OVERALL PAVING AND SITE PLAN

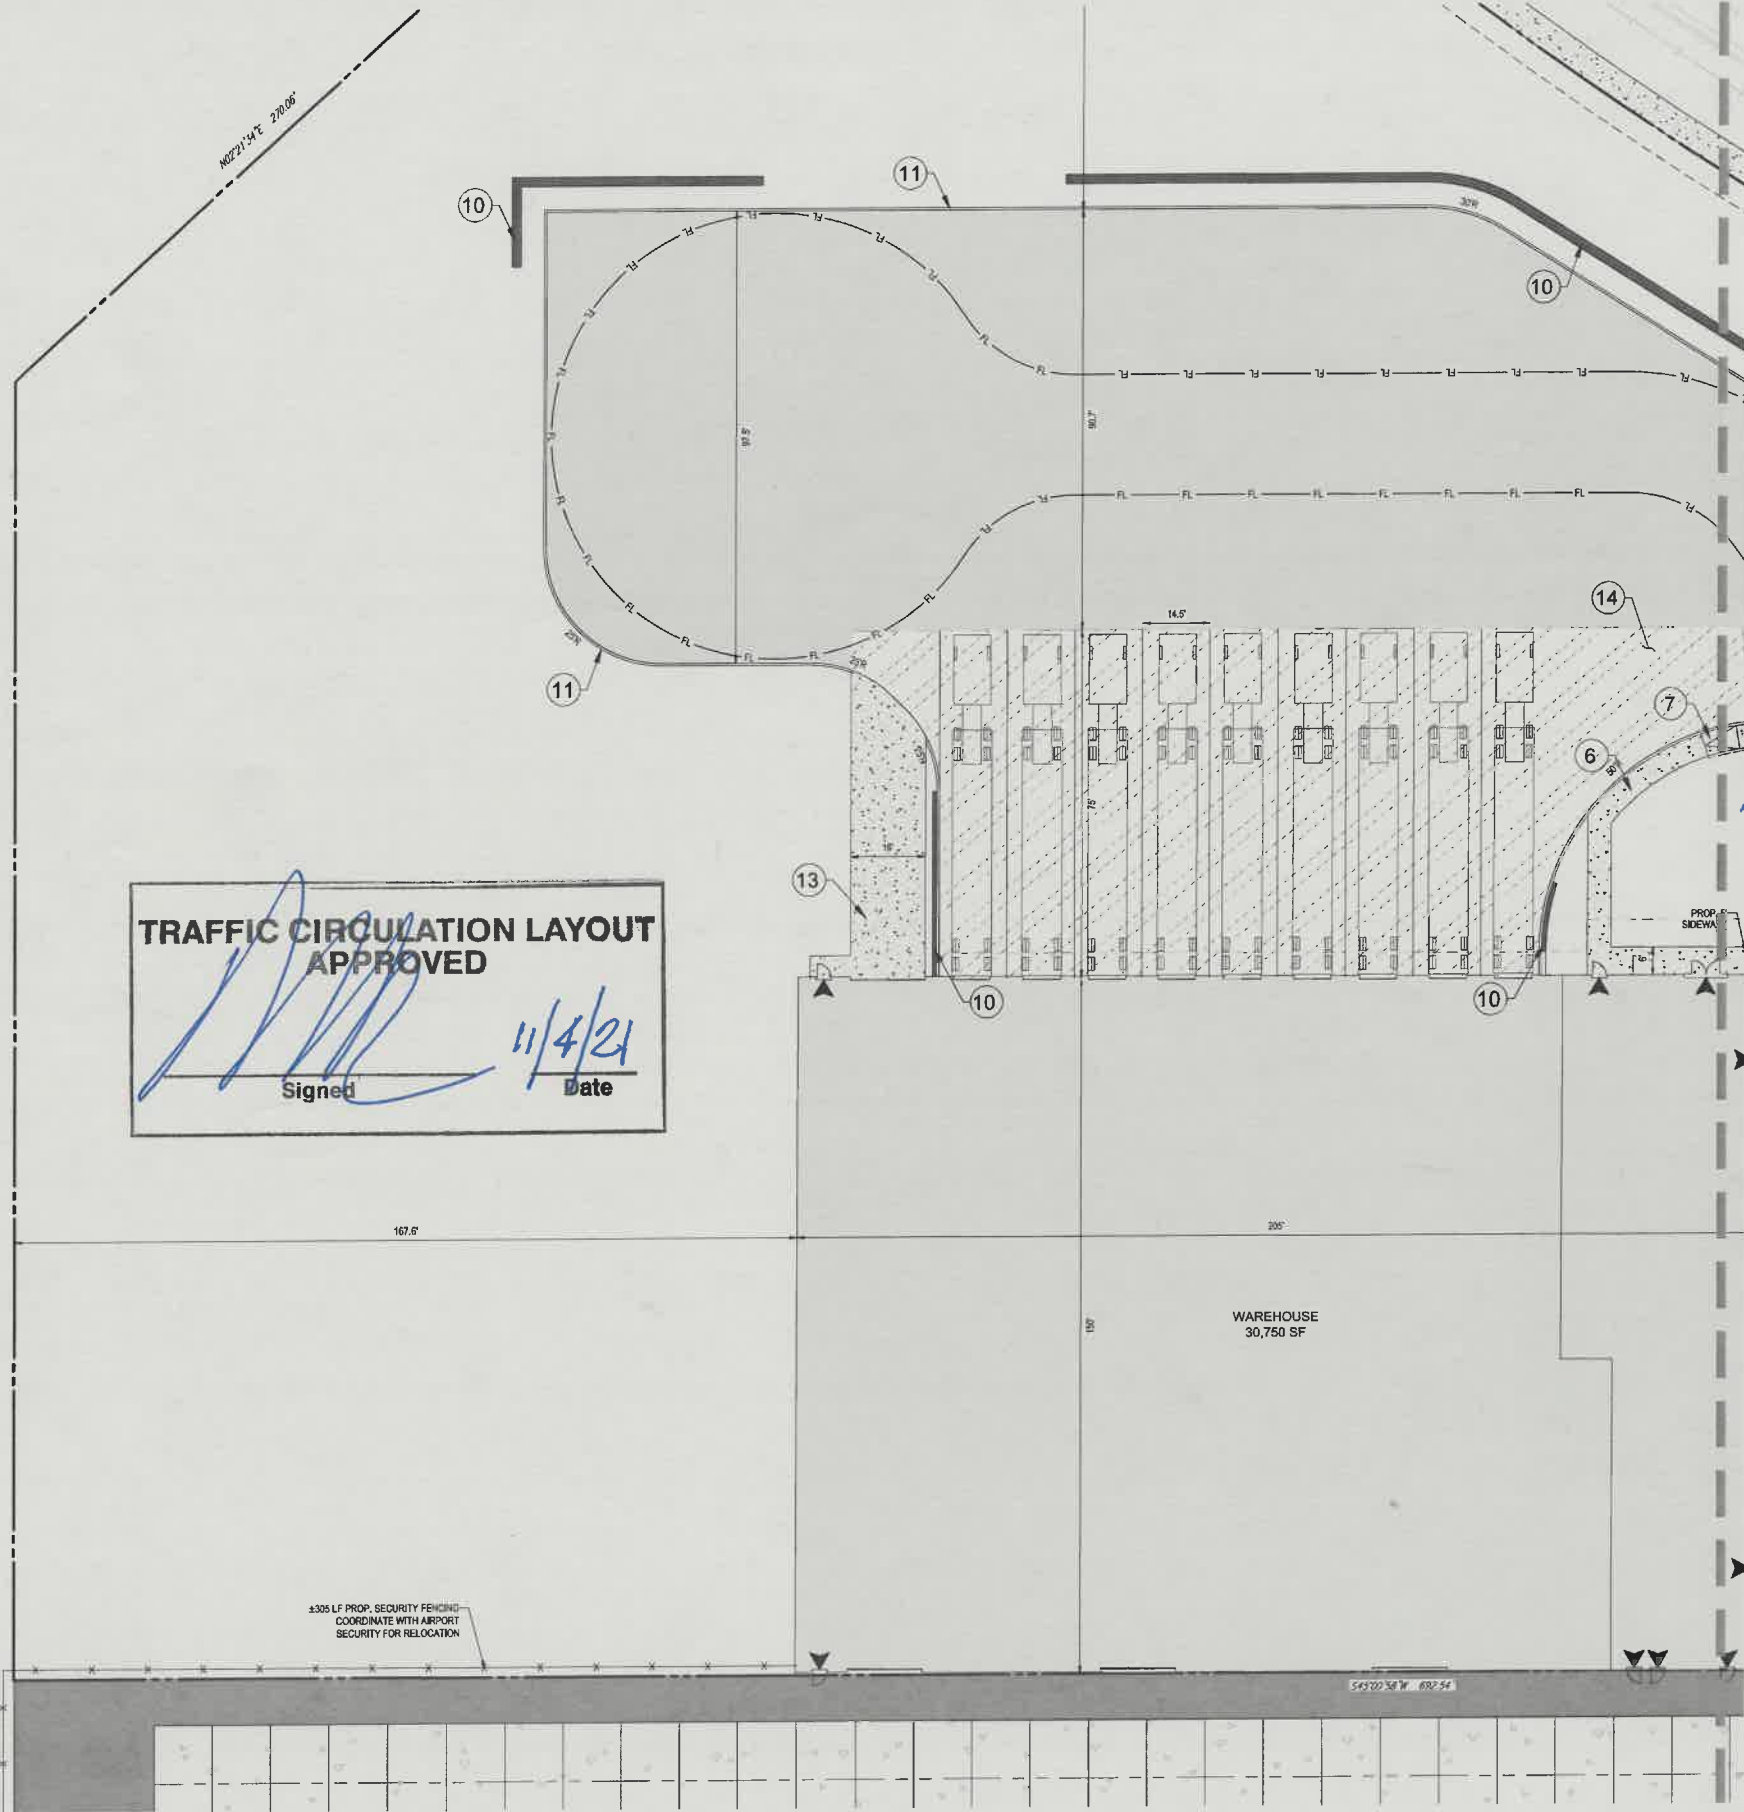
Add note: provide 4:1 tie taper to existing elevation

* please Reference detail sheets for all proposed infrastructure

Proposed ADA ramp per COA Std dwg 2445

Reference Sht. 907 and adjust ADA accessible space/aisle to it!!!

① provide MC -> pmt. markings.
② Motorcycle sign

why?

landings 2' min 6'x6'

provide curve radii's

Note 6
 proposed 6' sidewalk per
 COA Std chug 2420

Note 7
 Proposed ramp
 per
 COA Std chug
 2445
 or
 Reference
 Sht. C-901 & 902
 for corner
 ramps

Note 11
 per COA Std chug 2415A (6' C+G)

Add note:
 taper C+G
 to zero
